**Planning Department
Transportation Development Services**

November 9, 2015

**Re: Weck's Restaurant
730 Juan Tabo NE
Traffic Circulation Layout**
Engineer's/Architect's Stamp dated 11-2-15 (K22-D006A)

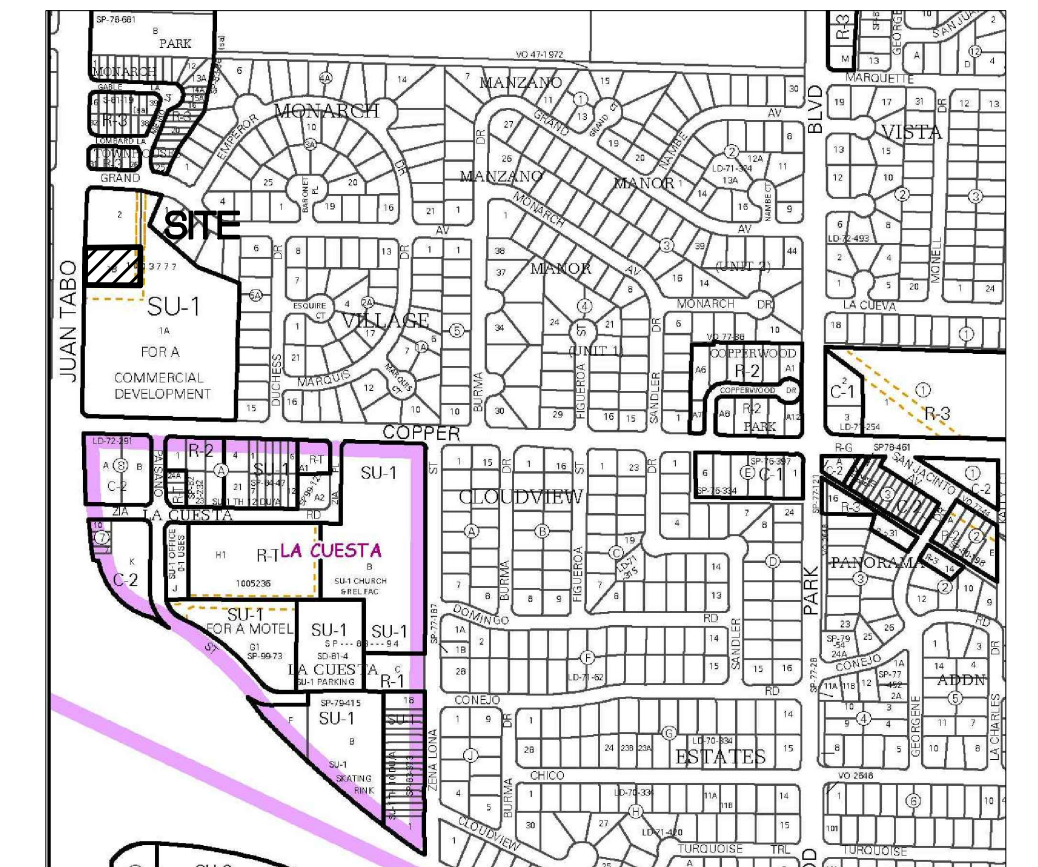
1. Identify and dimension the medians and curb cuts on Juan Tabo Blvd.
2. The ADA accessible parking sign must have the required language per 66-7-352.4C NMSA 1978 **"Violators Are Subject to a Fine and/or Towing."** Please show detail of ADA parking sign language.
3. Per the DPM, a 6 ft. wide ADA accessible pedestrian pathway is required from the public sidewalk to the building entrances. Please clearly show this pathway from Juan Tabo Blvd. and provide details.
4. Service vehicle and/or refuse vehicle maneuvering must be contained on-site; provide a copy of refuse approval.
5. Please provide a sight distance exhibit (see the *Development Process Manual, Chapter 23, Section 3, Part D.5 Intersection Sight Distance*). Please provide this detail for entrance/exits on Juan Tabo Blvd.

6. Please add the following note to the clear sight triangle: "Landscaping and signage will not interfere with clear sight requirements. Therefore, signs, walls, trees, and shrubbery between 3 and 8 feet tall (as measured from the gutter pan) will not be acceptable in this area."
7. Please include a copy of your shared access agreement with the adjacent property owner.
8. Unused curb cuts must be replaced with sidewalk and curb & gutter. A build note must be provided referring to the appropriate City Standard drawing.
9. Please include two copies of the traffic circulation layout at the next submittal.
